Harnett County
420 McKinney Pkwy
LILLINGTON, NC 27546
Phone:
Fax:

SUBJECT: **SFD2503-0086**
SINGLE FAMILY DWELLING

Here are the results of all Inspections located at **250 KOERNER LN:**

FOUNDATION PLAN

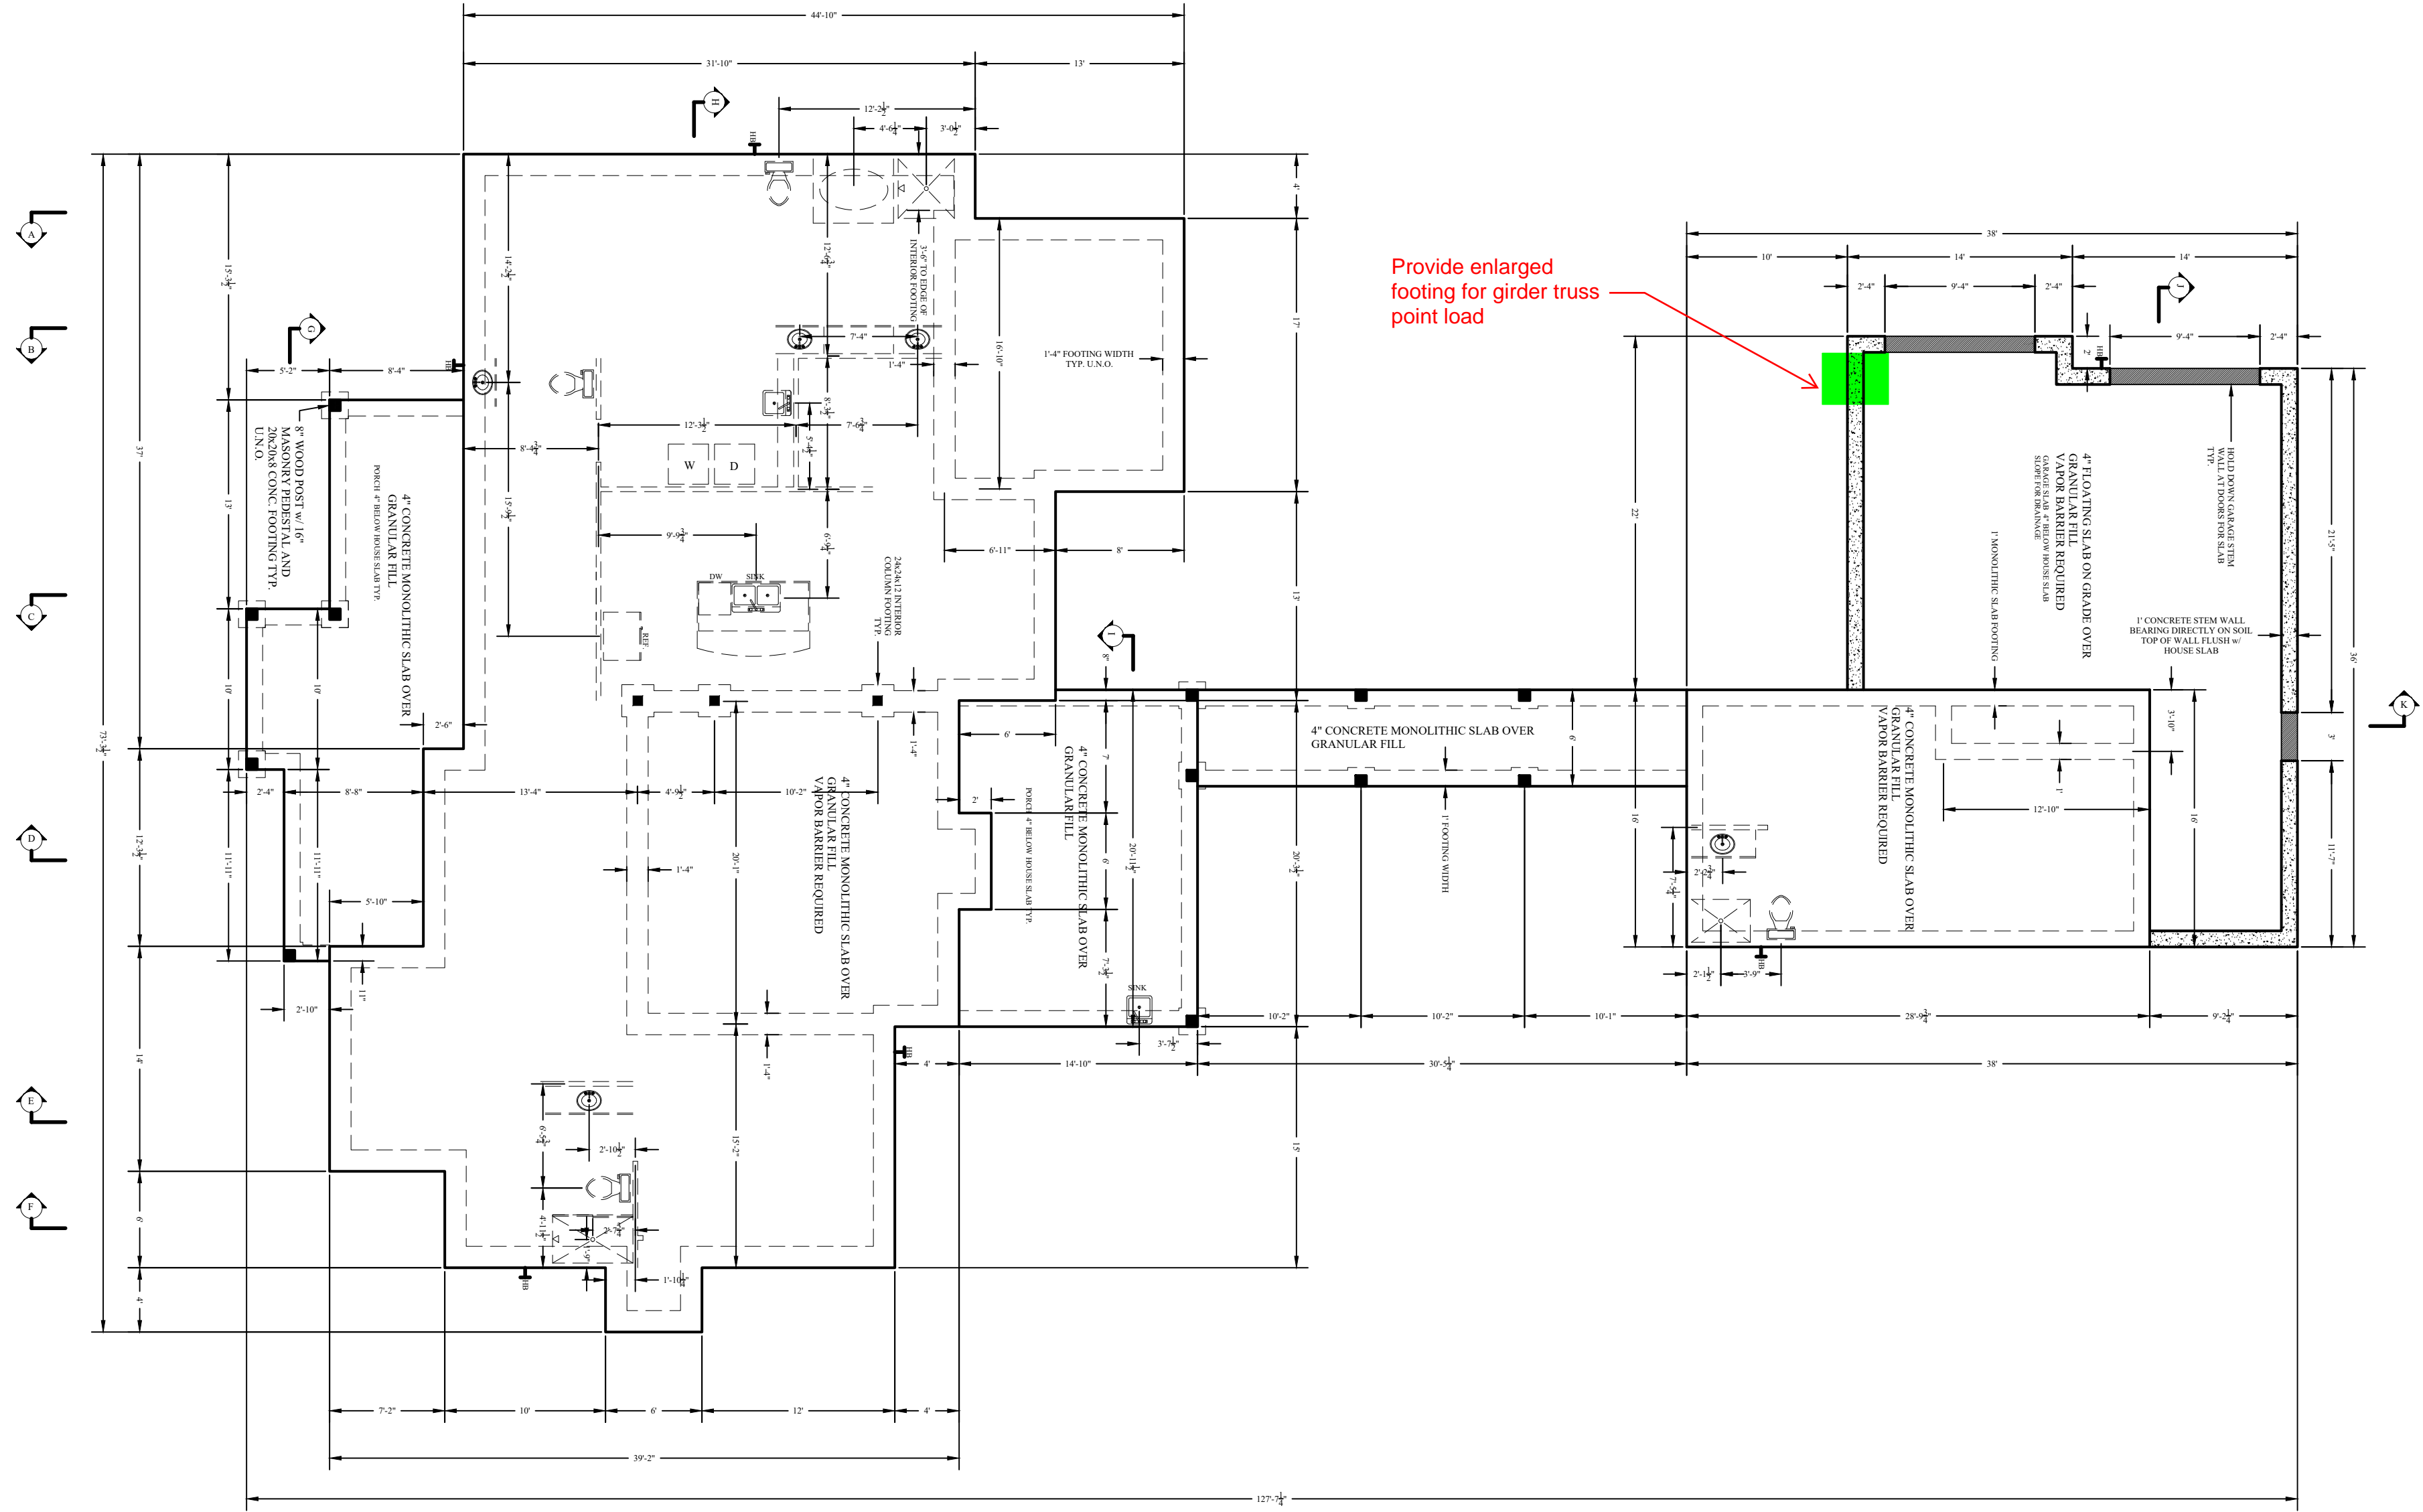
Inspection Type: MONO SLAB
Scheduled Date/Time: 6/3/2025
Completed Date/Time: 6/3/2025
Inspector: James T Hall
Result: DISAPPROVED
Remarks:
Notes: 1. Footings at garage doors needs to be continuous 2. Insulation needs to be cut min 8" from bottom of footings where connecting to other footings for continuous and open the same with as the footings 3. Missing point load footings on porches
